| Application number: 2023/93667   |                                                                                      |
| What is the application for?:    | Outline application, including the consideration of access for vehicle into the      |
| Address of the site or building: | Storthes Hall Student Village, Storthes Hall Lane, Kirkburton, Huddersfield, HD8 0WA |

| Type of comment: An objection

Appendix F Drawing 18092/IN/06 Traffic Regulation Orders (Option B)

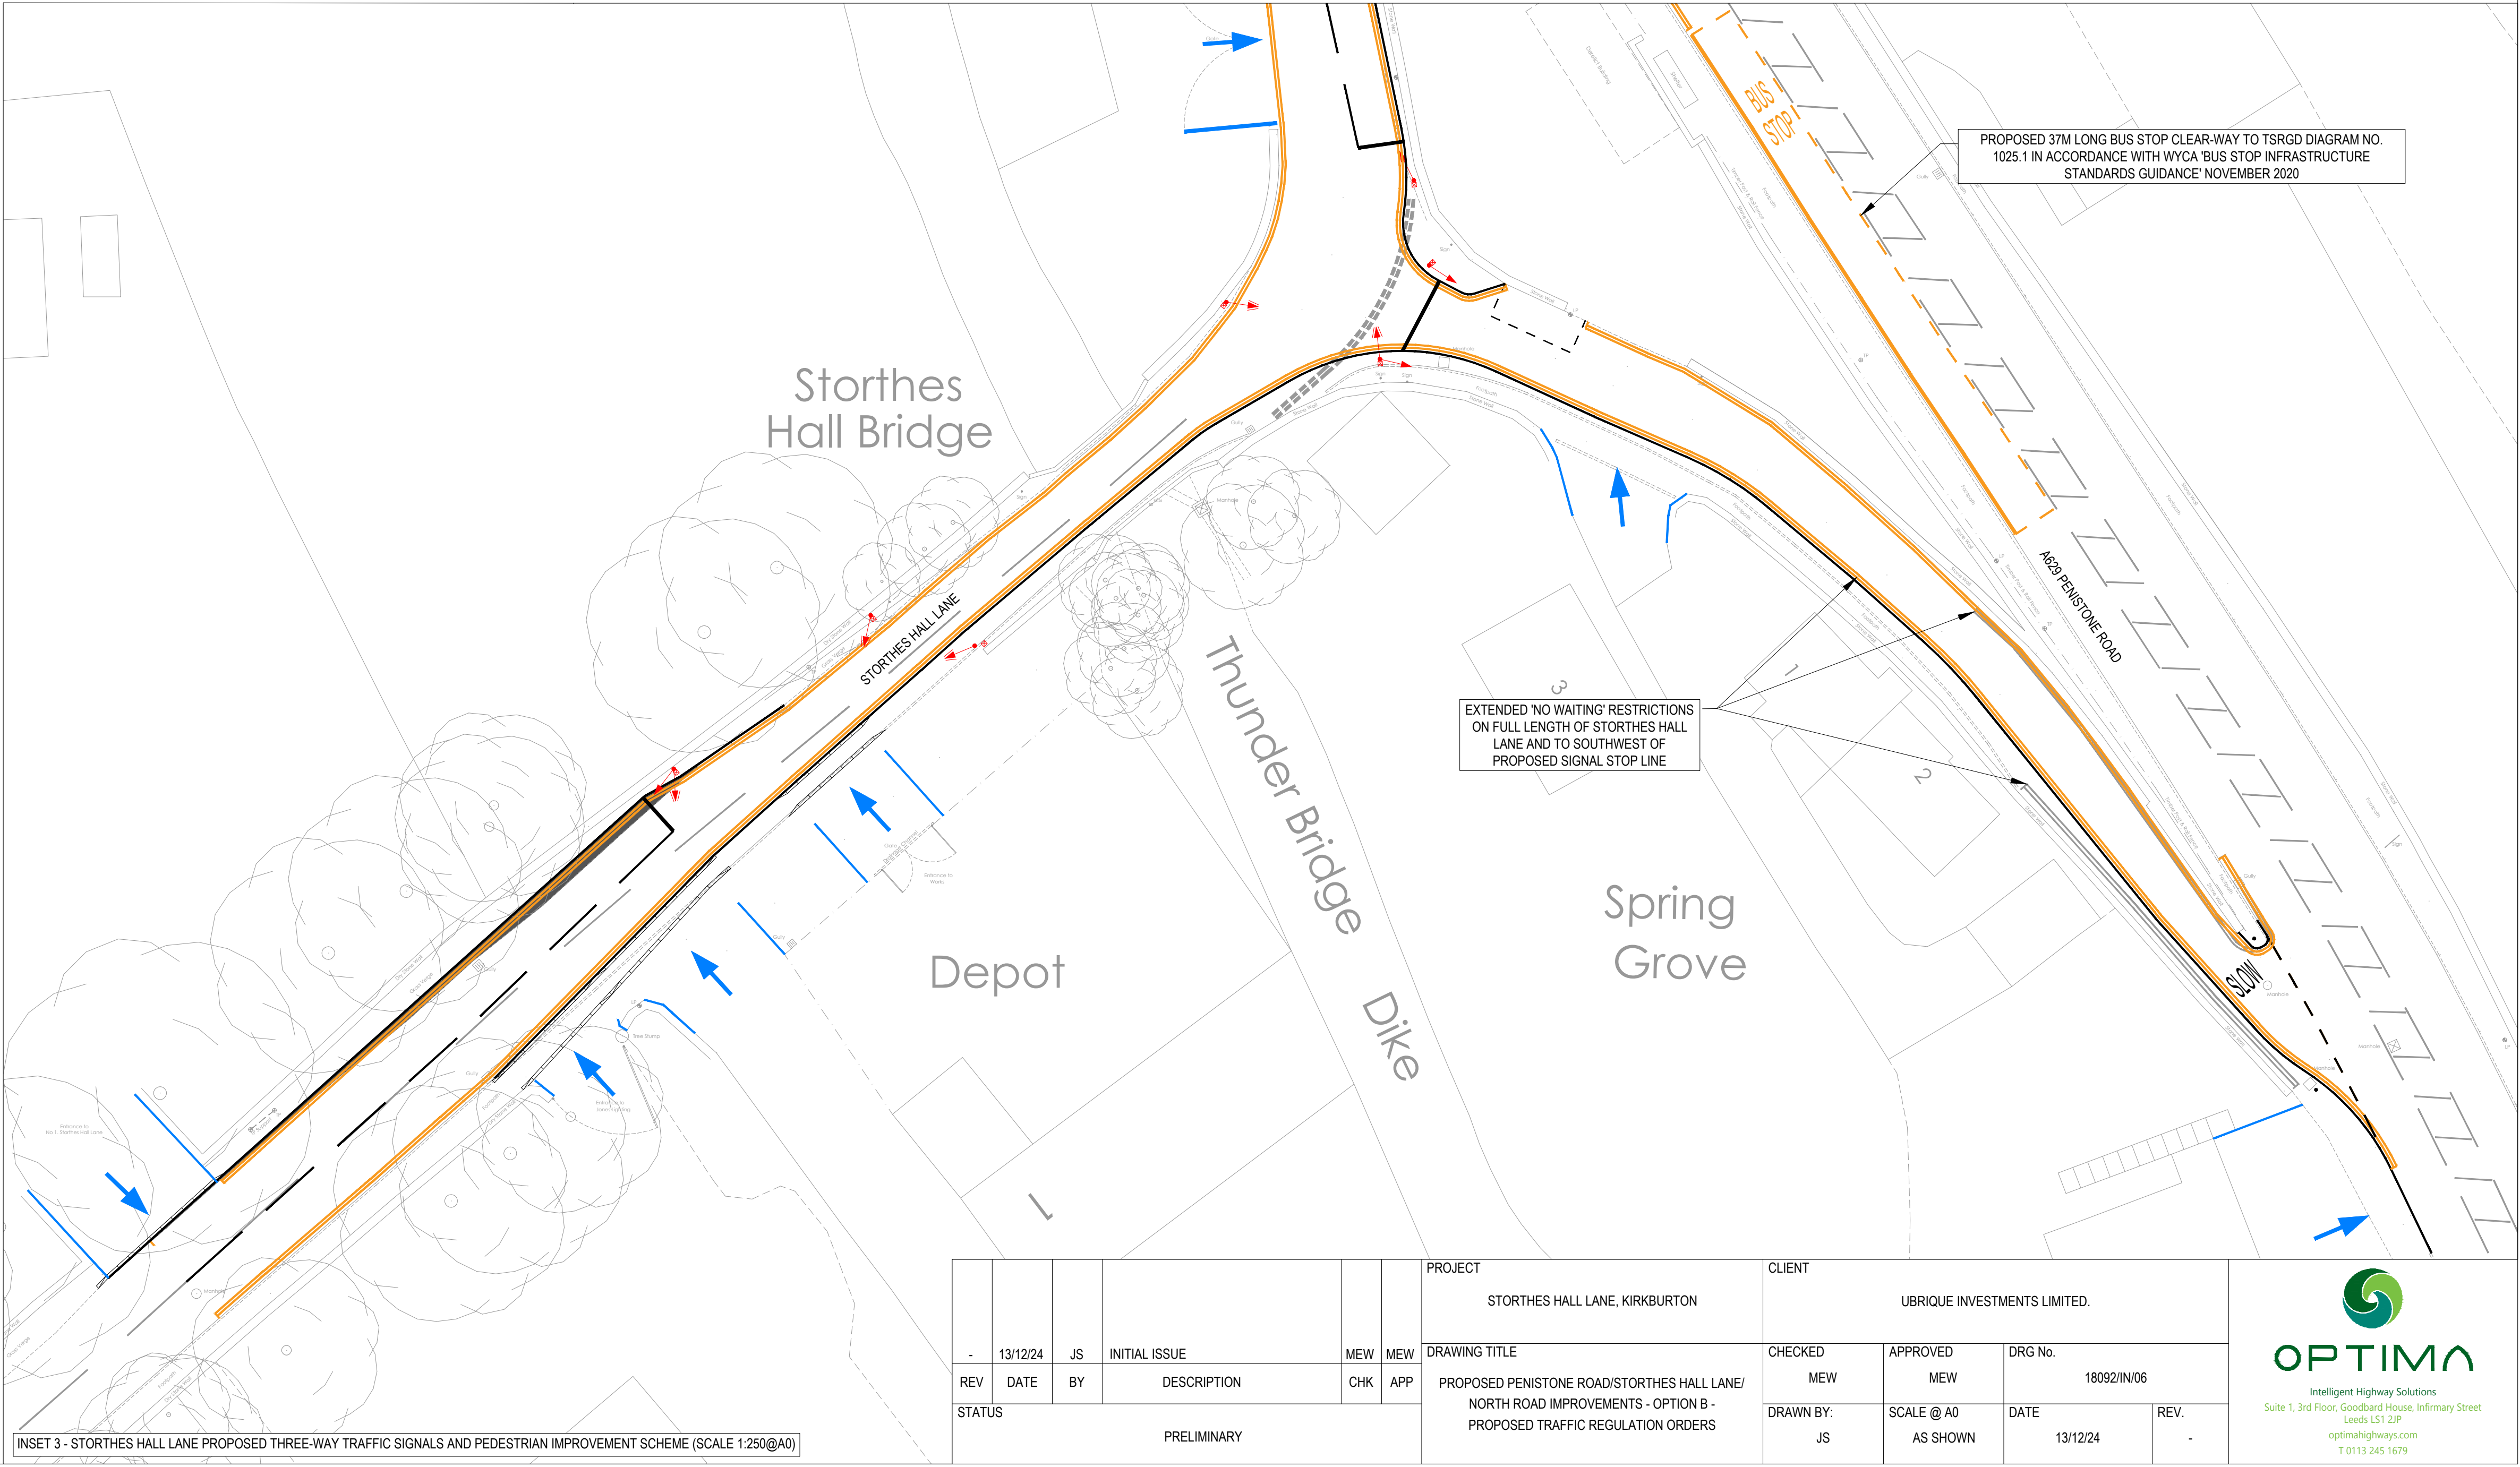
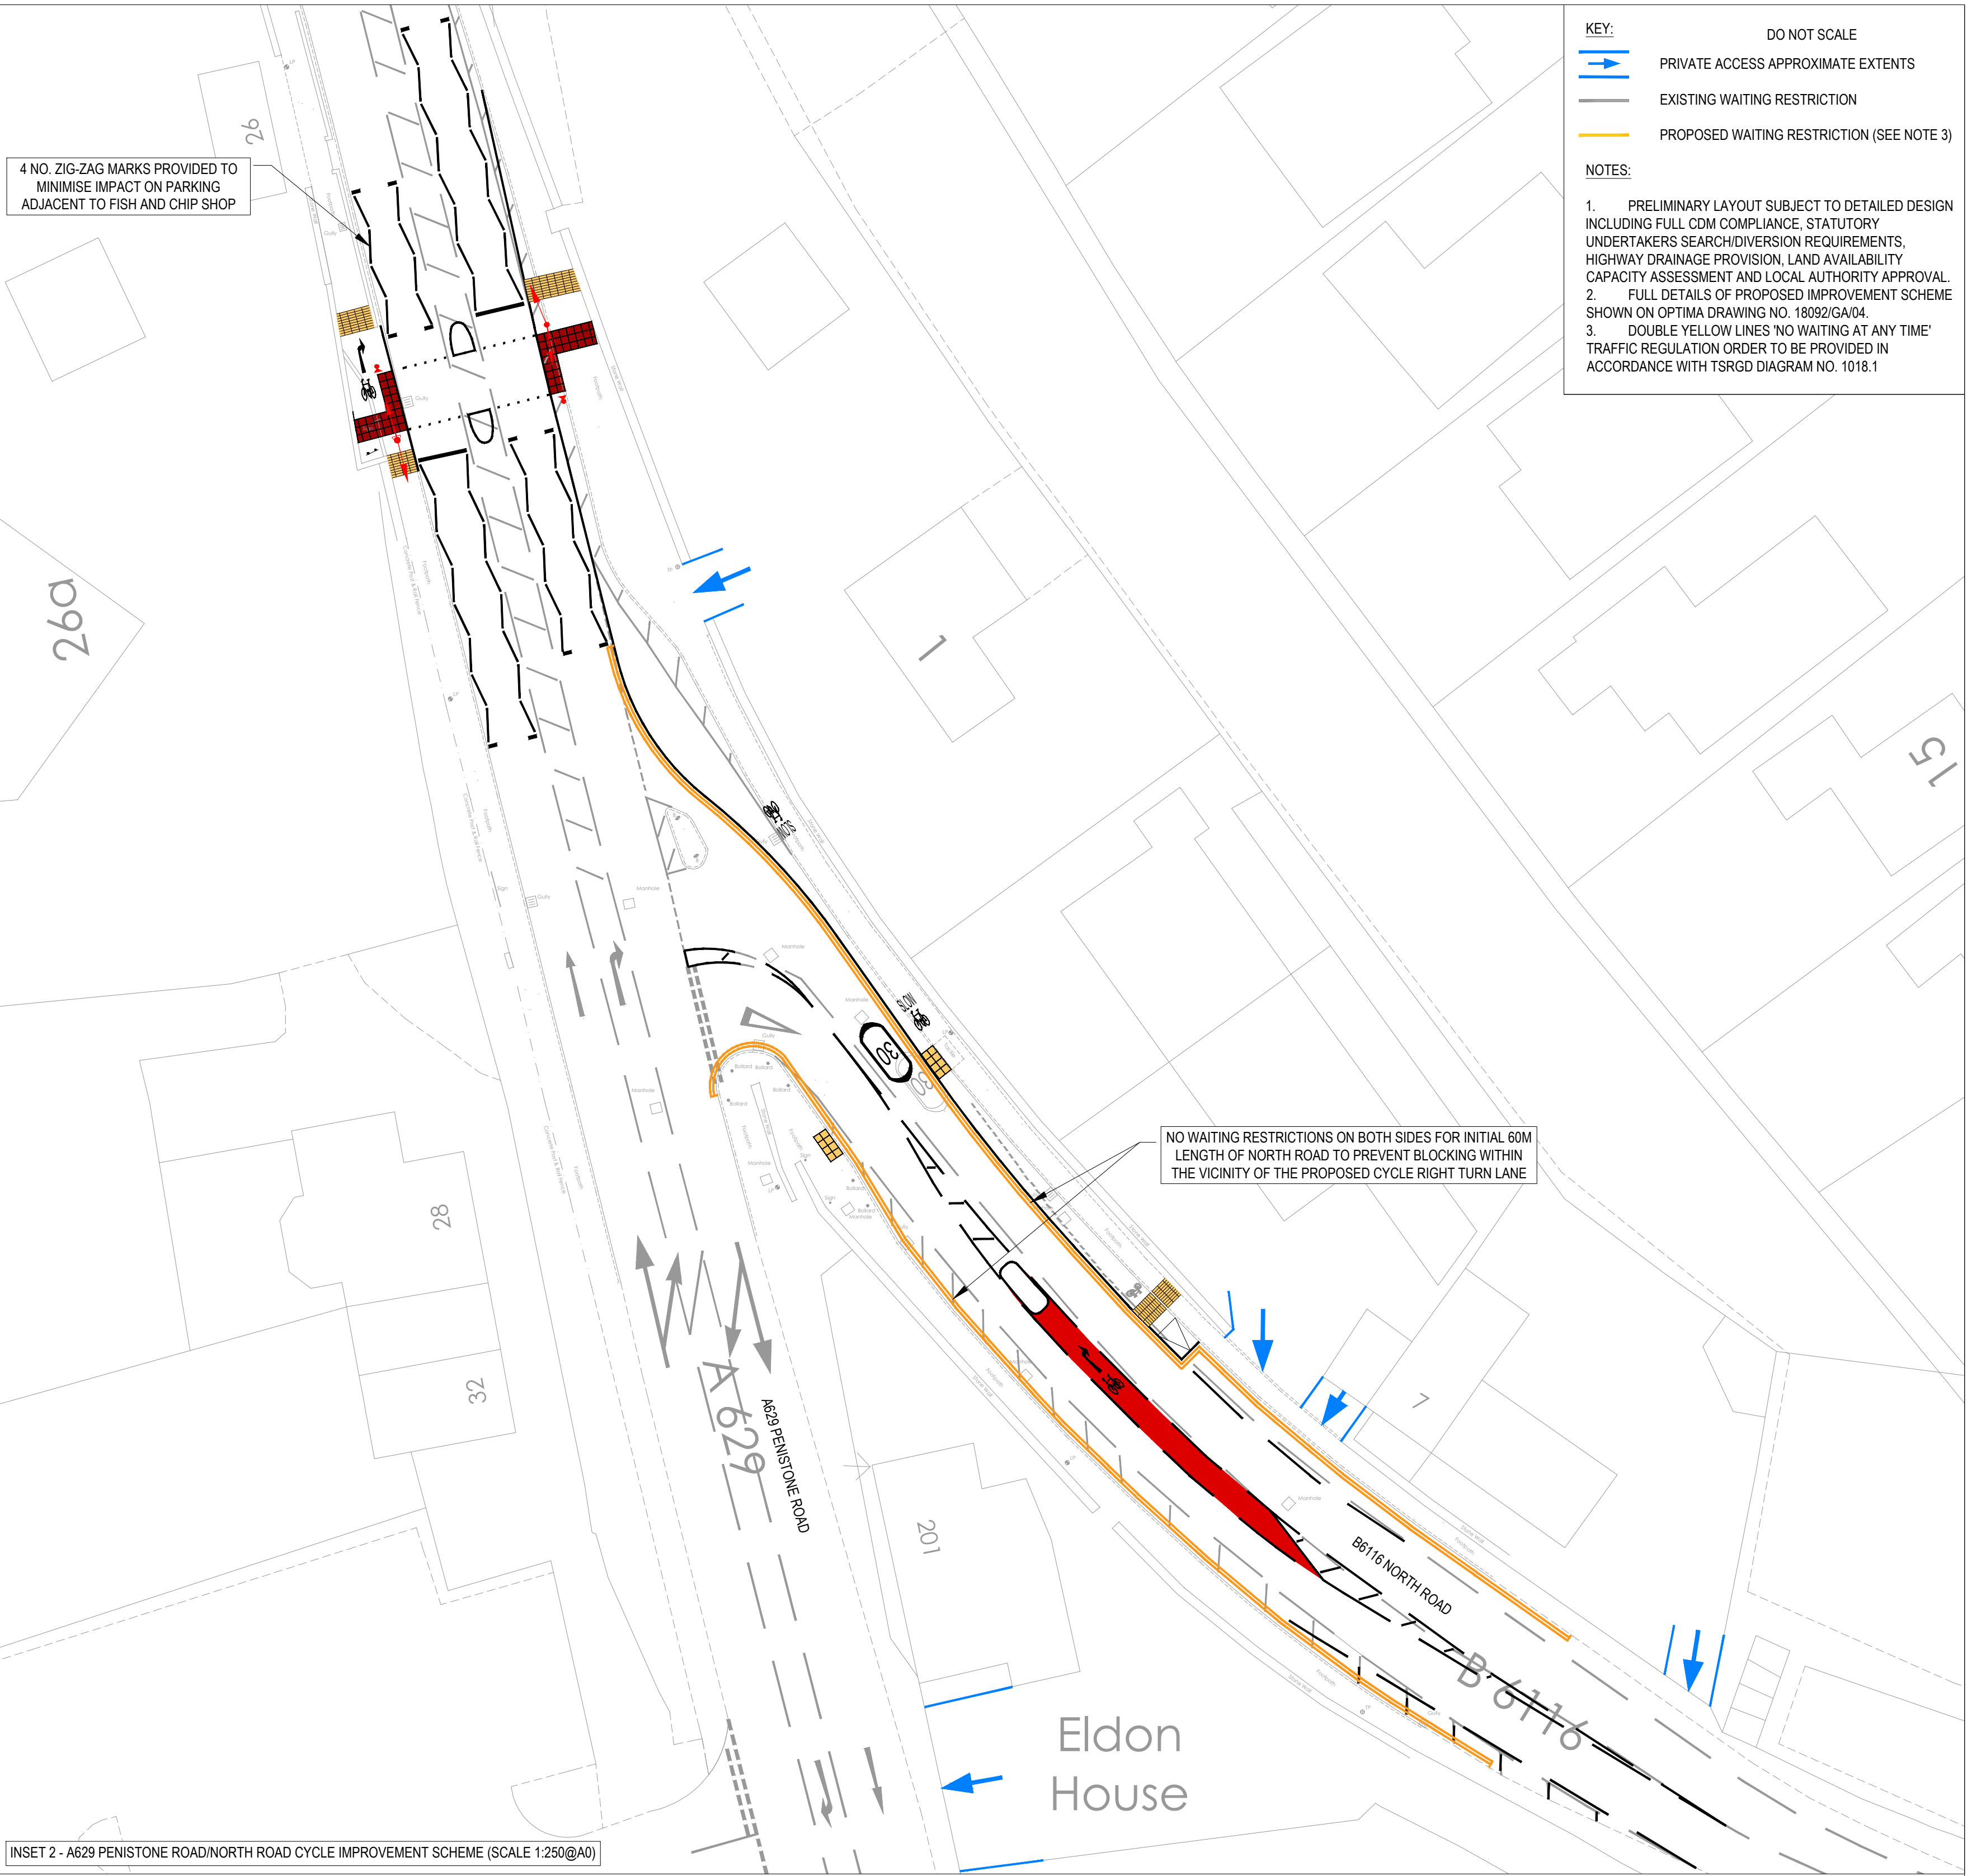
| <p>I am very concerned about the impact this proposal would have on car parking for myself and my neighbours around the junction between Storthes Hall Lane and Penistone Road (re. Plan #1080066).</p> <p>The proposal would reduce the available parking significantly, potentially forcing some residents to park quite some distance away from their homes if they were unlucky enough to find the very limited available parking occupied.</p> <p>Also, if residents have visitors (or deliveries for example) where are these people going to park?</p> <p>The majority of residents including myself are not young, and I worry that this potential lack of parking may cause problems in the future - isolation even - for people who are older and who may have reduced mobility.</p> <p>I am also concerned about the apparent lack of consultation made with myself and my neighbours on this matter, given the potential impact on us.</p> |     |
